**East West Rail Network Phase 2 The Scheme  
Railway From London Road Bicester To Station  
Road Launton**

**20/03365/DISC**

**Proposal:** Discharge of condition 7 (a)(b)(ii) (landscaping proposals at Bridge 34A Station Road) of 18/01430/TWAO

ECOLOGICAL COMPENSATION SITE A4  
133735\_2A-EWR-OXD-XX-DR-L-010002  
APPROVED CONDITION 12A

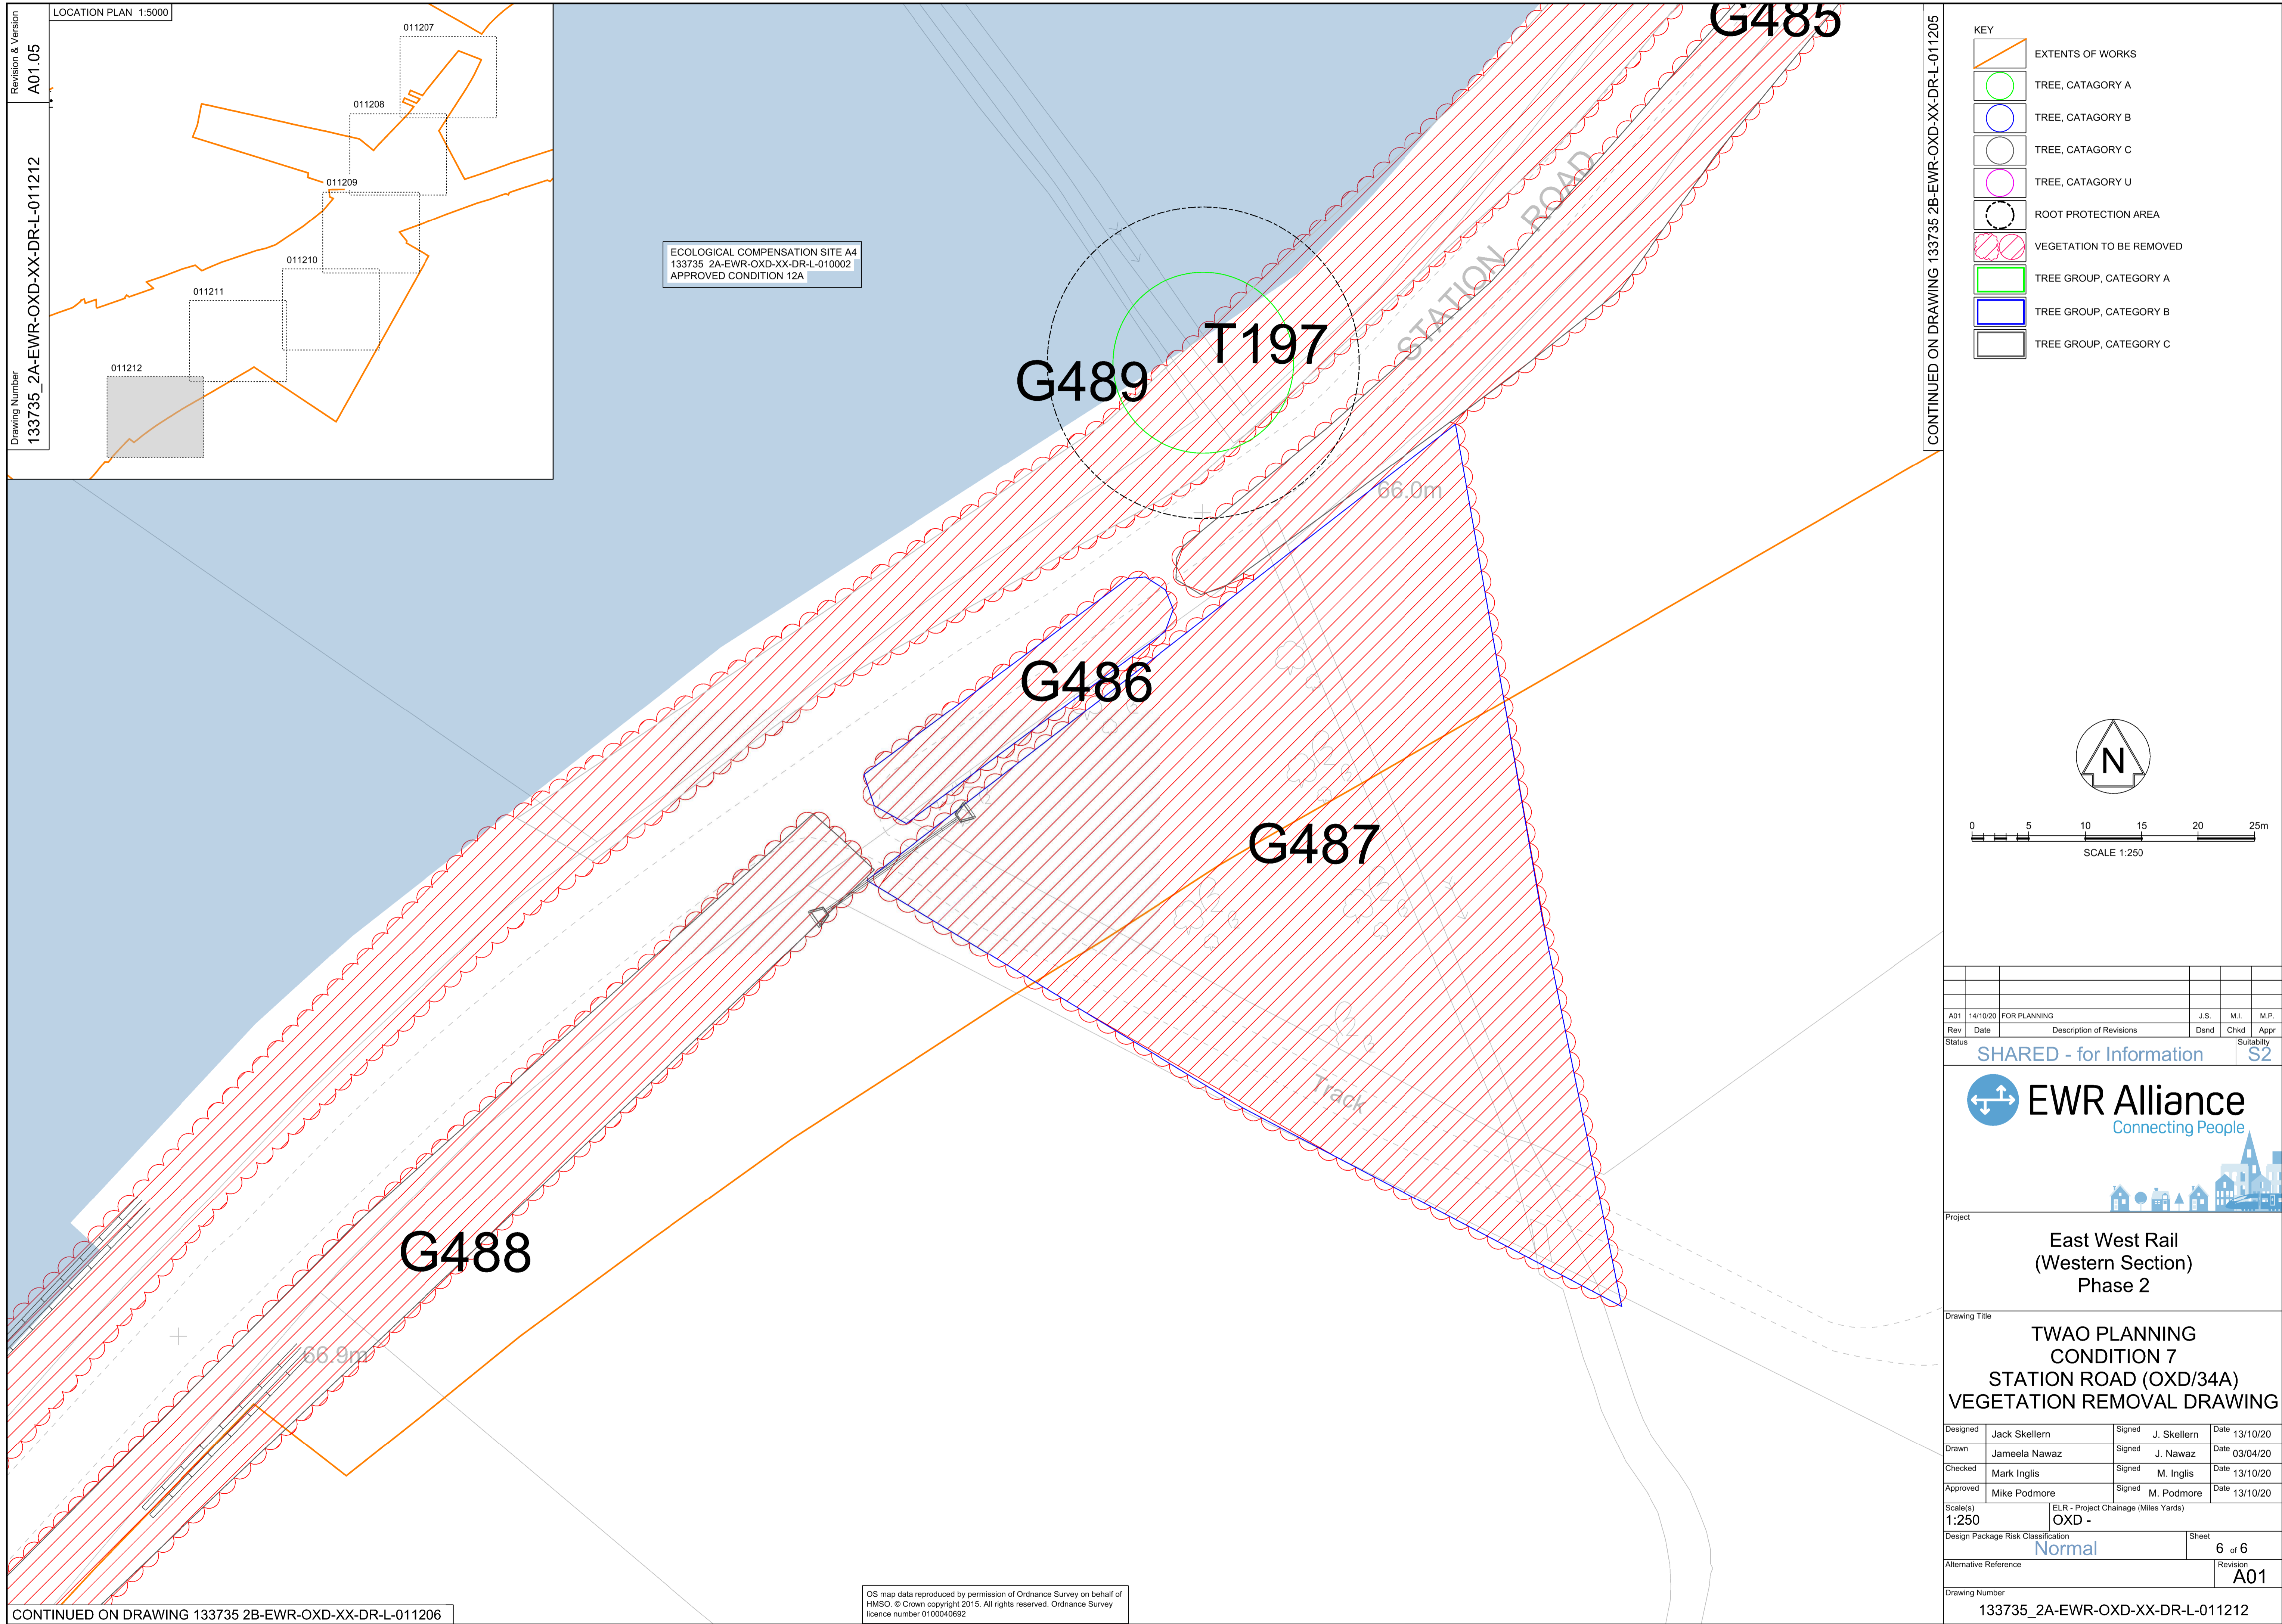
4.1 CDC Landscape Officer – I still have concerns about the extensive loss of established vegetation to facilitate this railway. Is there any compensatory measures included? How is the East West Rail Alliance going to improve the situation with additional native tree and shrub planting? The written specification appears to be fine.

5.1 The application has been assessed by the Council's Landscape Officer and his comments above were forwarded in December 2020 to the applicant for further consideration of the submission. A response from the applicant was received in March 2021 advising that compensation for the loss of vegetation would be provided along the whole of the network corridor and in addition ahead of the works, 19 ecological compensation sites have already been provided and in many cases are now becoming established.

- 5.2 Having regard to the above comments, it is considered on balance that whilst the loss of vegetation at this particular area is regrettable, that overall, the scheme delivers adequate compensation planting and landscaping elsewhere. The application is therefore recommended for discharge accordingly.
- 5.3 The original application was EIA development. The application submission seeks to deliver the landscaping scheme as set out in the original submission and has no additional impacts above those already considered in the original ES. Therefore, the EIA is considered sufficient for the purpose of considering the information provided for this condition and it has been taken into account in considering this subsequent application.
